From: Bradley Gasawski
Sent: Thursday, August 1, 2024 3:06 PM
To: Pat Deneen
Cc: Bradley Gasawski
Subject: FW: PD-24-00001 Roslyn Ridge West - Notice of Application

I'm forwarding recent communication with the county surveyor, Justin Turnbull. The BL-24-00012 Blue Jay Land Co. project has adjusted the property lines of the property accessed via Double O Road. Please submit an updated site plan for the PUD / Short Plat that represents this adjustment in property lines. Thank you.

Subject: PD-24-00001 Roslyn Ridge West - Notice of Application

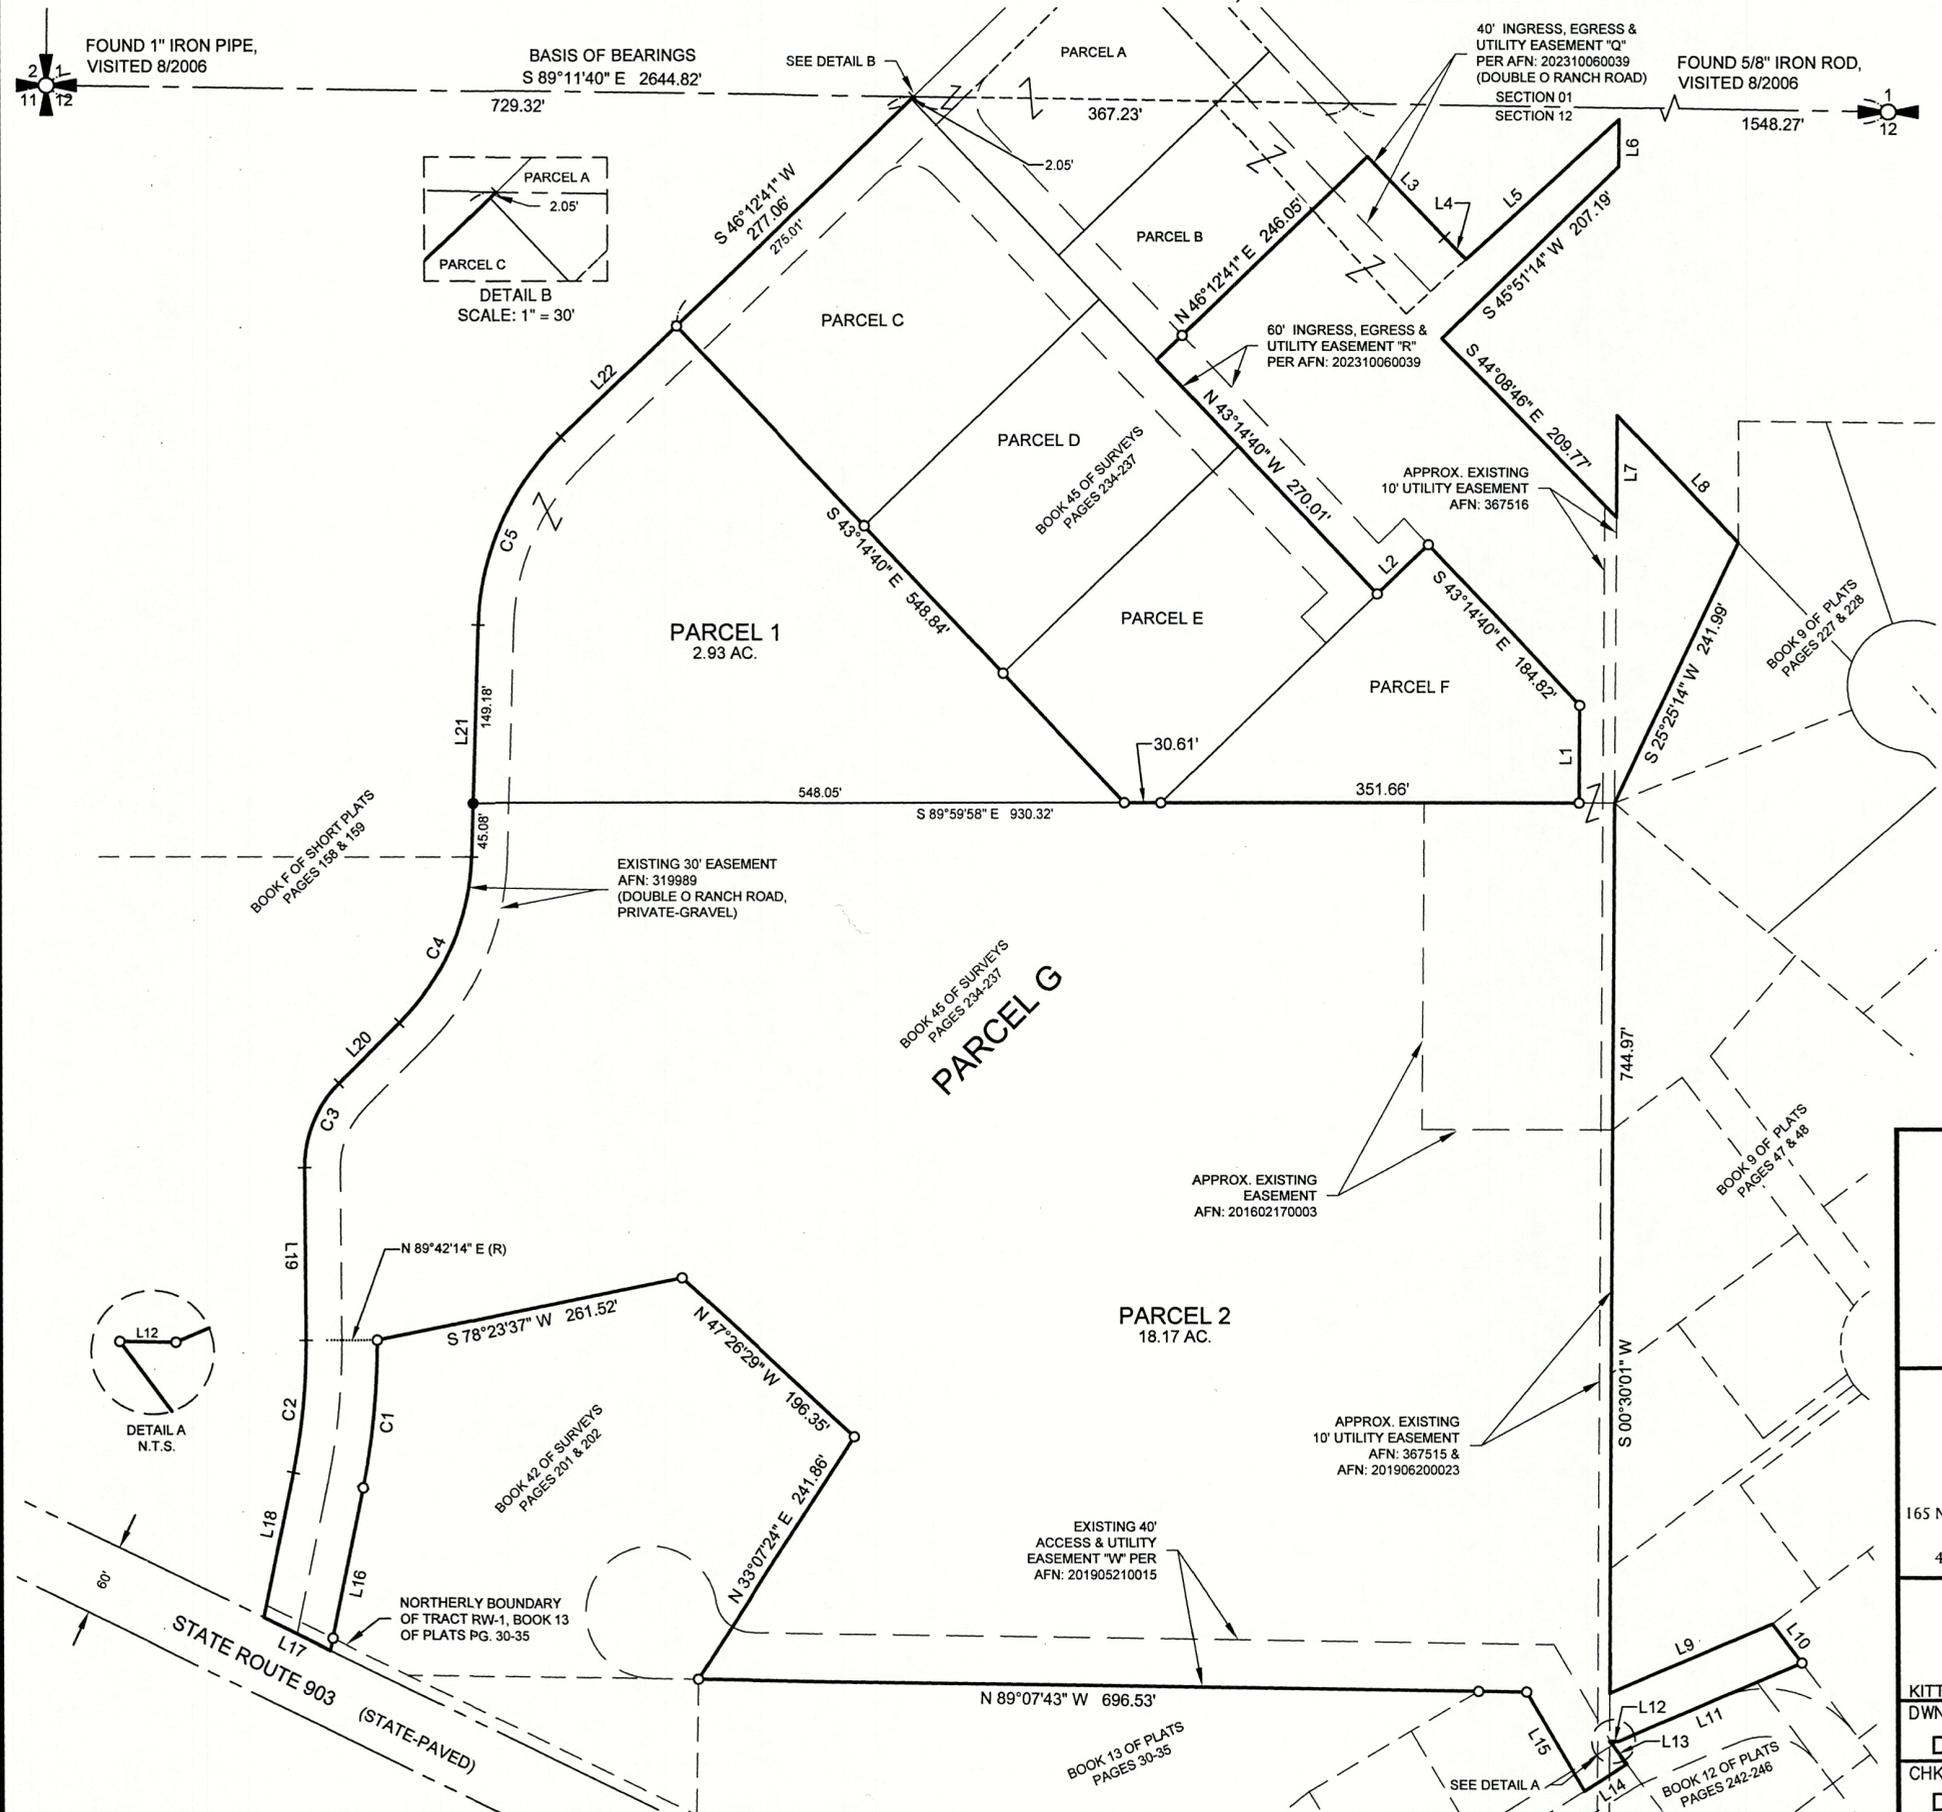
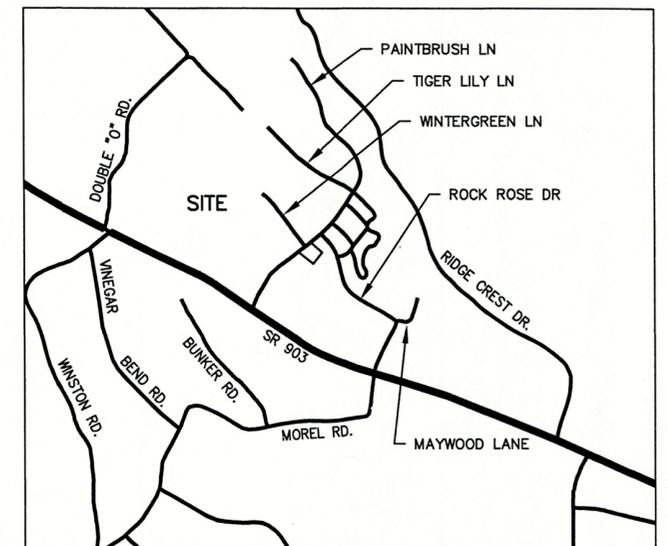
Bradley,
Comments remain the same. The newly recorded survey will need to be referenced, and lot lines representing the new positions shown.

There is a conflict between the Short Plat proposed on this PUD, and BL-24-00012. Both applications represent current parcel lines.

Whichever one is filed second will need to be adjusted to represent the revised boundaries of the one filed first.
